KIRKLEES METROPOLITAN COUNCIL INVESTMENT & REGENERATION SERVICE

DELEGATED DECISION TO DETERMINE APPLICATIONS FOR LISTED BUILDING CONSENT

Reference No:	2026/65/92217/W
Site Address:	Stalley Royd Farm, Stalley Royd Lane, Jackson Bridge, Holmfirth, HD9 7HX
Description:	Listed Building Consent for alterations to convert one dwelling to two dwellings
Recommending Officer:	Joanna Rednall

DECISION – GRANT LISTED BUILDING CONSENT

scale 1:100 date 03/2026 sheet size A2 dwg. no. 26/1311/04

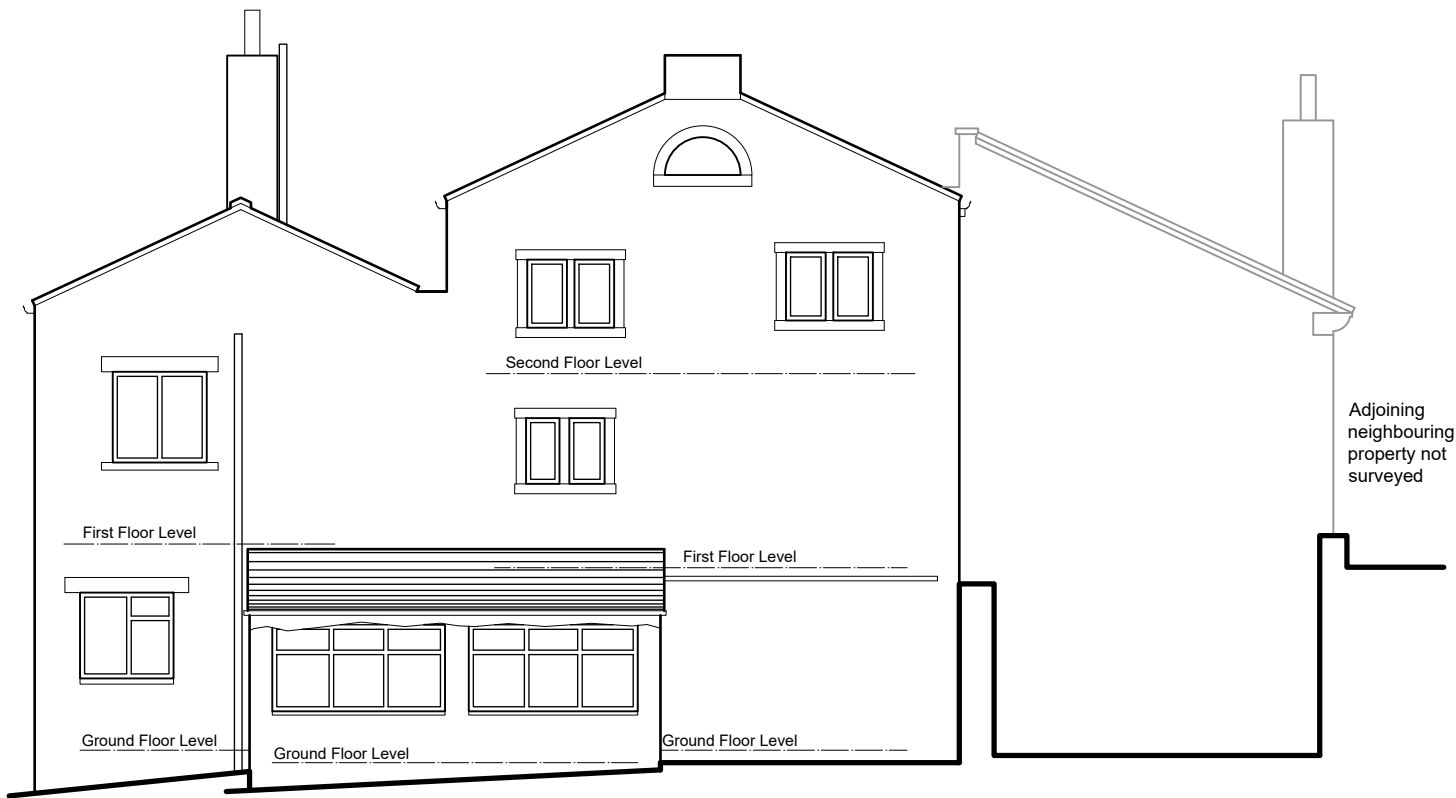
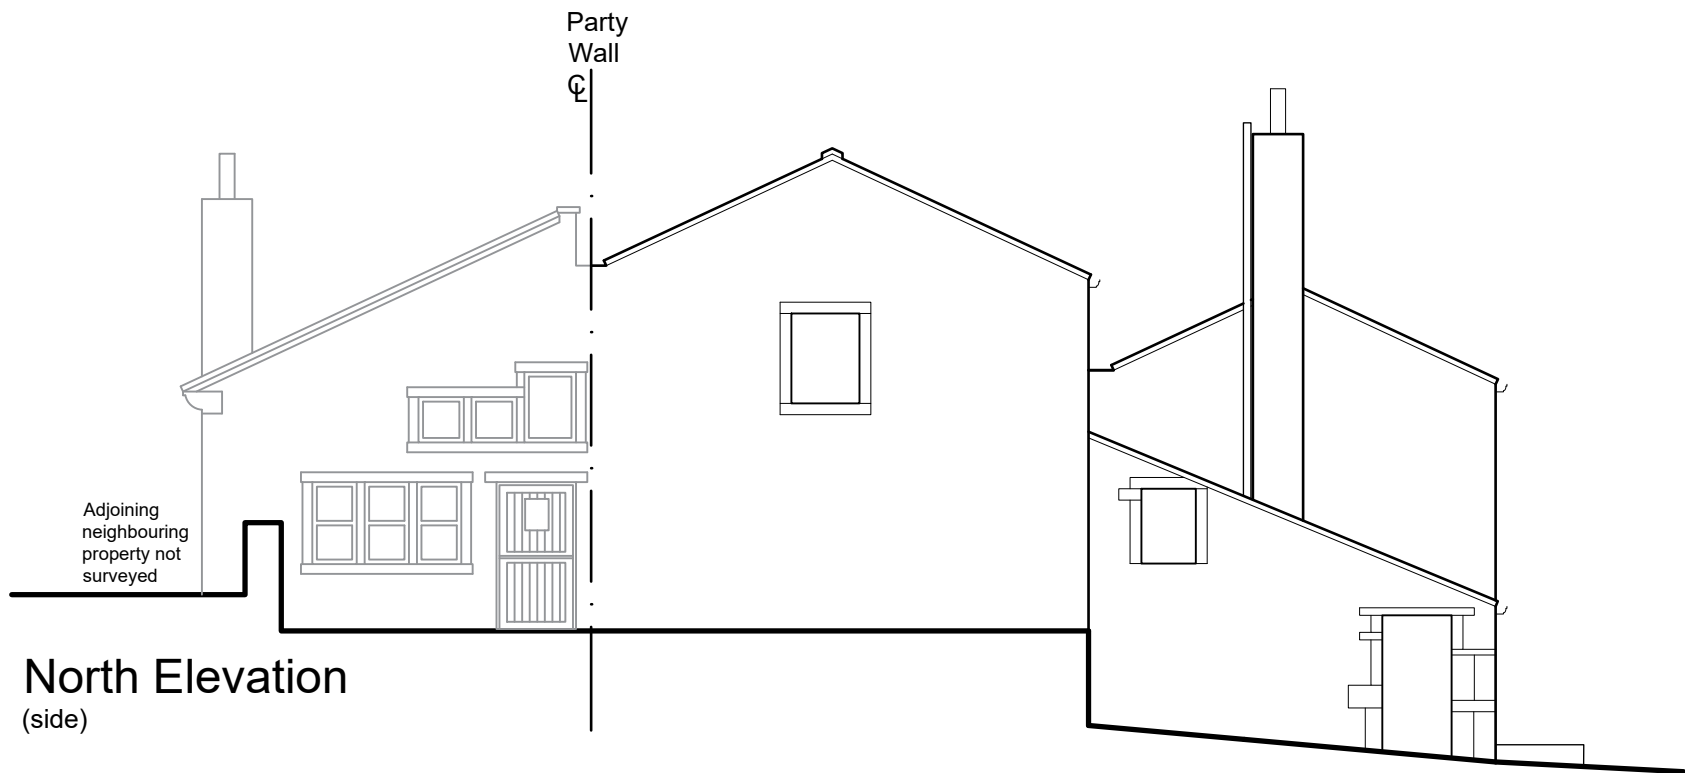
Conservation Officer (Kirklees Council) – no objection, however recommend for the French doors to the rear / west facing elevation to be constructed from timber.

The Council's Conservation and Design Officer has been verbally consulted during the course of this application and has raised no objection in principle to the proposal. However, the Officer has recommended that the proposed French doors on the rear (west-facing) elevation should be constructed in timber.

The submitted plans identify powder-coated aluminium or timber as options for the proposed sliding doors, which would be sized to correspond with the existing window opening. The applicant's agent has advised that the west-facing elevation is exposed to prevailing weather conditions and that powder-coated aluminium is preferred on grounds of durability and performance. The agent has also noted that the doors would replace an existing modern uPVC window.

In considering the proposed material, consideration has been had to the location of the opening, the character of the elevation and the existing window to be replaced. The west-facing elevation is less prominent than the principal elevations, and the existing uPVC window is not identified as a historic feature. The proposed doors would be installed within the existing opening, with no change to the building's external envelope.

On this basis, officers consider that the use of powder-coated aluminium at this location would result in a limited degree of harm to the special architectural and historic interest of the listed building. The proposal would therefore need to be assessed against the public benefits arising from the works, including the reinstatement of the building's historic dual-occupancy arrangement and its continued residential use.

3. The fixed/sliding door to the west / rear elevation hereby approved shall be either timber or powder coated aluminium framed and set back in the reveal by 100-125mm and not fitted flush with the external wall.
